**WELWYN HATFIELD BOROUGH COUNCIL
EXECUTIVE DIRECTOR - PLANNING, PUBLIC PROTECTION AND GOVERNANCE**

DELEGATED APPLICATION

Application No: 6/2018/1186/FULL
Location: 11 Hook Lane, Northaw Park, Potters Bar, EN6 4DA
Proposal: Subdivision of existing single dwelling into two dwellings, with the installation of a front door and window to facilitate conversion of a garage into a hall, corridor and utility room
Officer: Mr David Elmore

Recommendation: Refused

PLAN 9

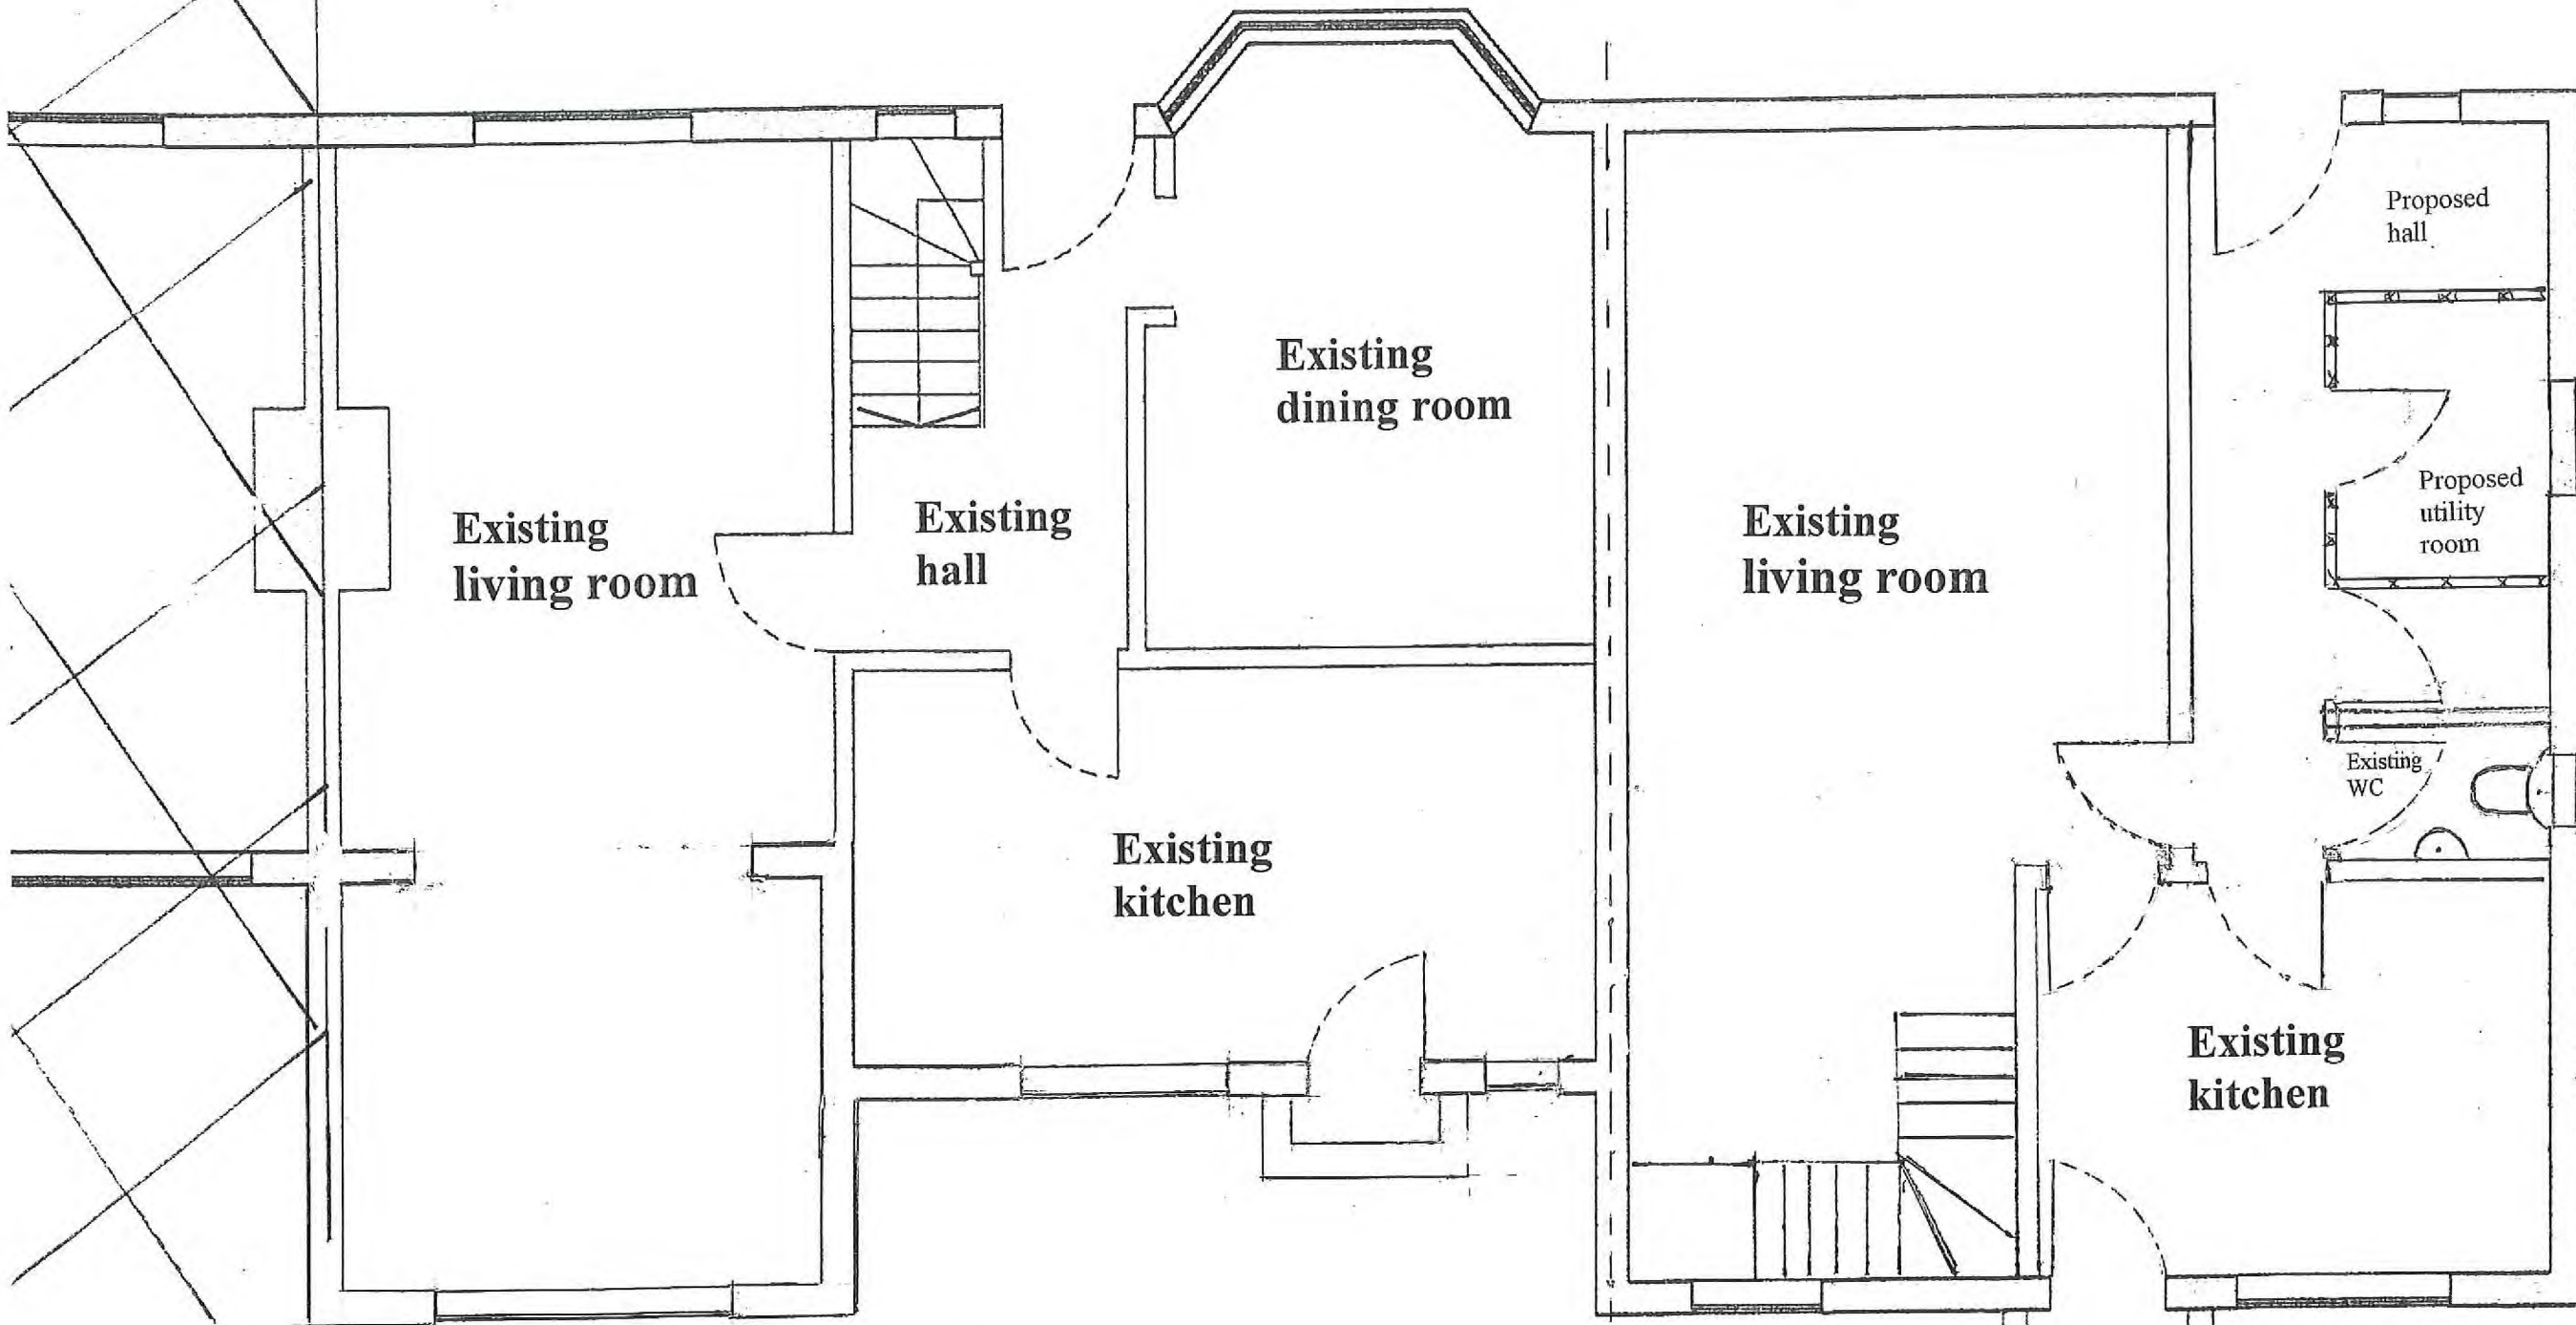
Proposed alterations include: installation of front door, high level ground floor side window,

PLAN 6

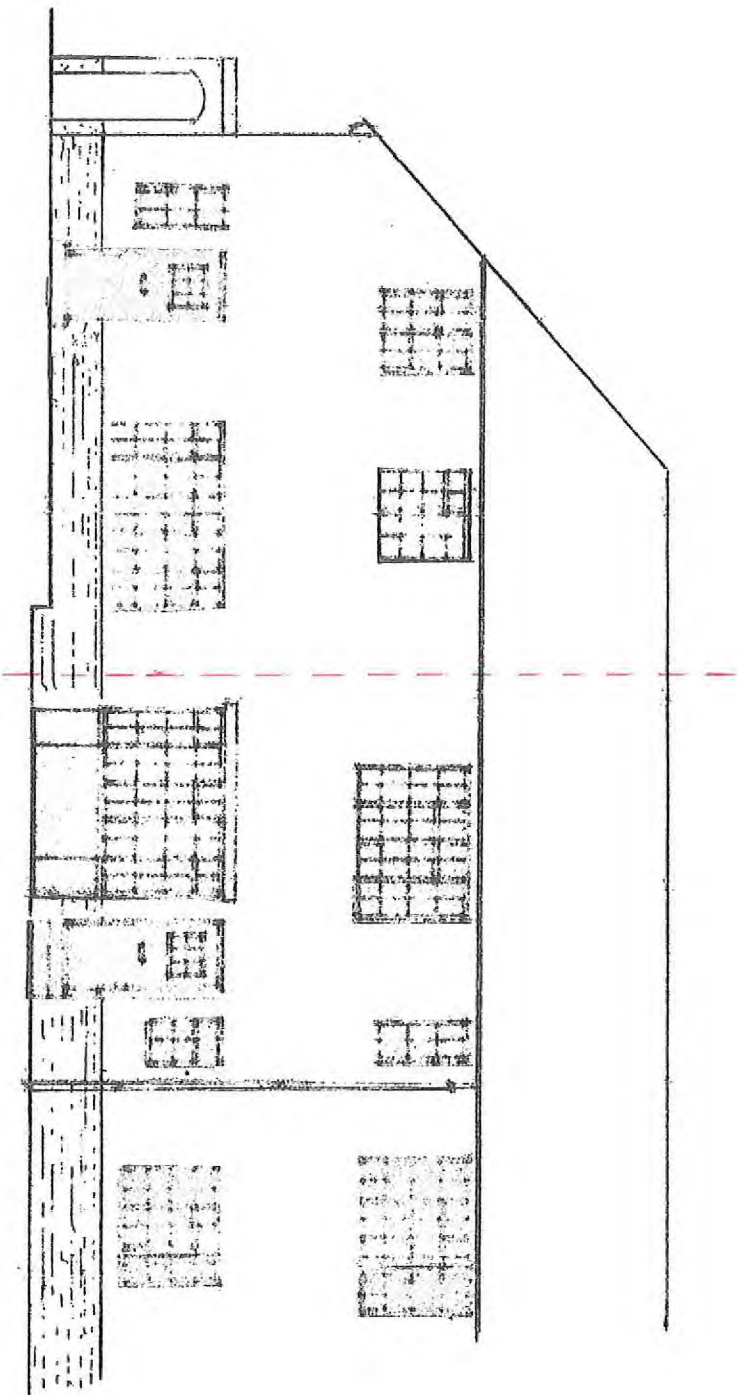
replacement of garage door with a window and laying of additional hard-surfacing in the front garden. The proposed fenestrations would be similar in design terms to the existing fenestrations and would not materially affect the external appearance of the building. The hard-surfacing provision would not harm the character and appearance of the building nor its area. Accordingly, the proposed alterations would maintain the existing design and character of the building and its area, in accordance with Policies D1 and D2 of the Saved Local Plan; the Council's SDG; Policy SP9 of the Saved Local Plan and; the NPPF.

HOOK LANE PROPOSED PLAN (PARKING)

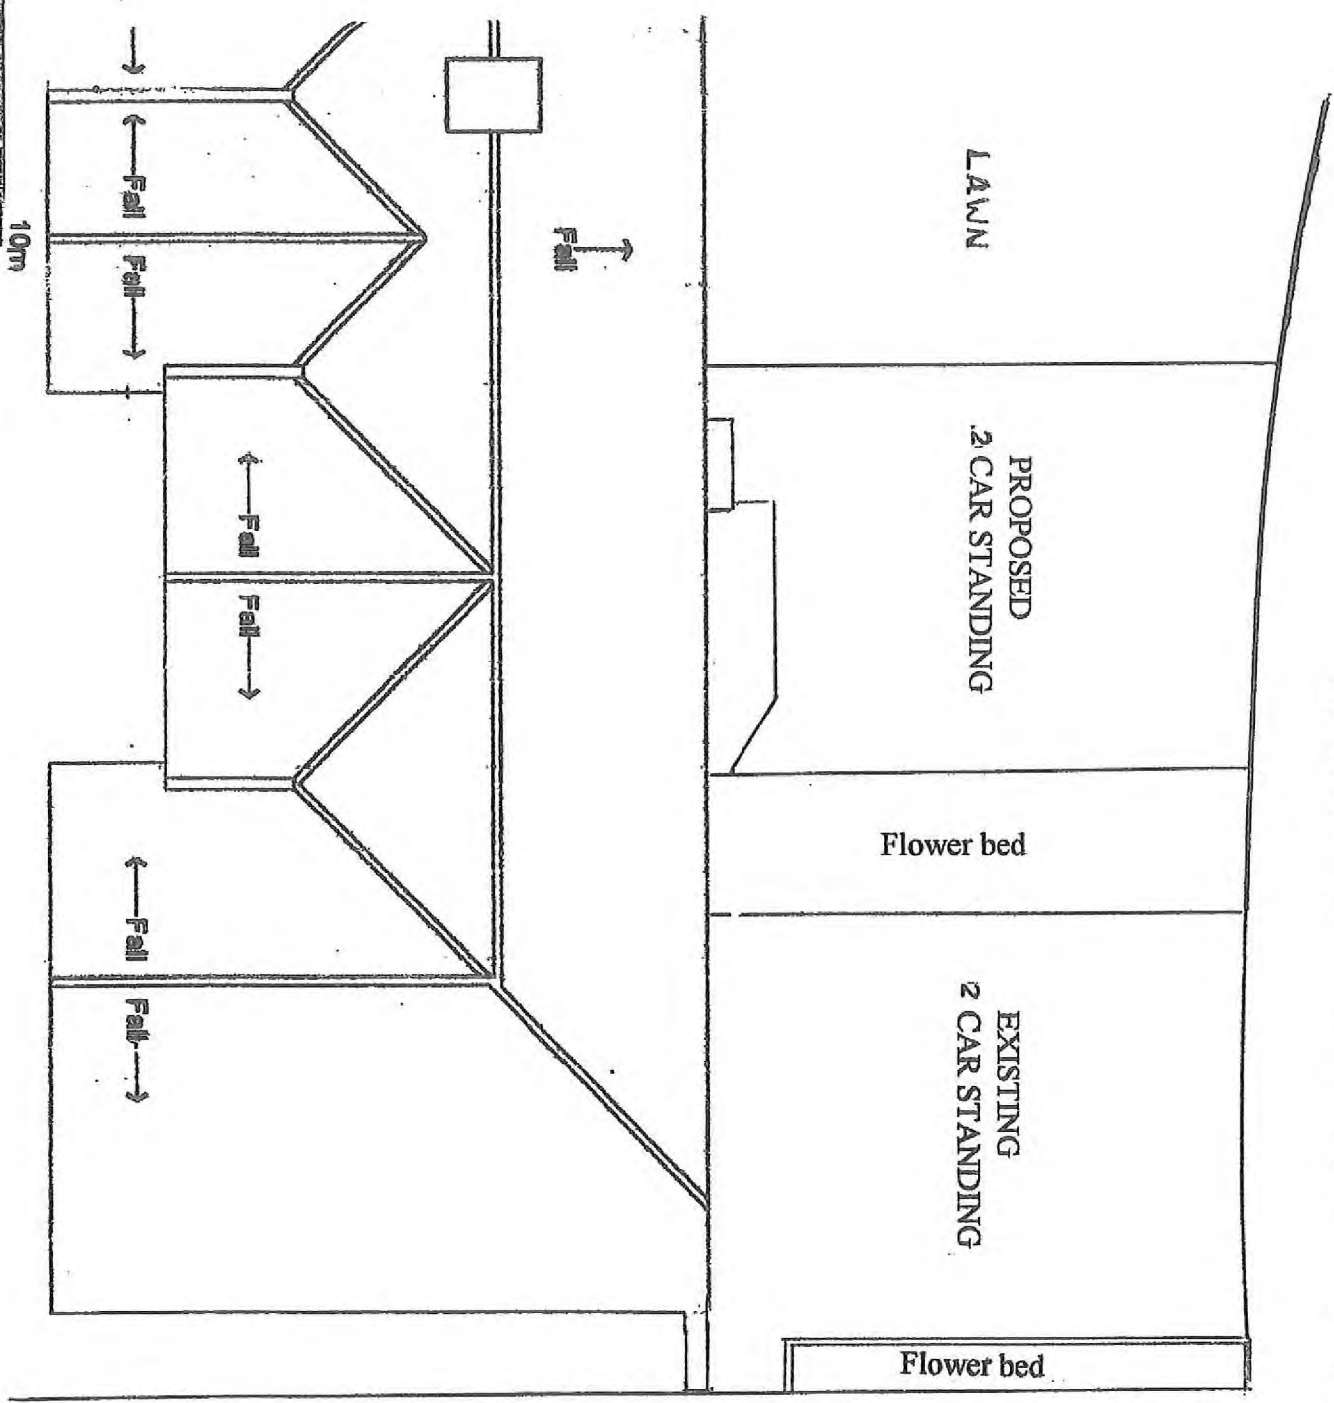
No. 1 Hook Lane objects to the proposed development, considering that the division of the dwelling with the conversion of the front garden to hard standing for car parking, would alter the rural semi-detached cottage character of this pleasant lane and bridle path.

In terms of parking, each 3-bed dwelling would benefit with 2 off-street car parking spaces. This level of provision accords with the Council's Car Parking Standards contained within the SPG and therefore, the development is deemed acceptable in this respect.
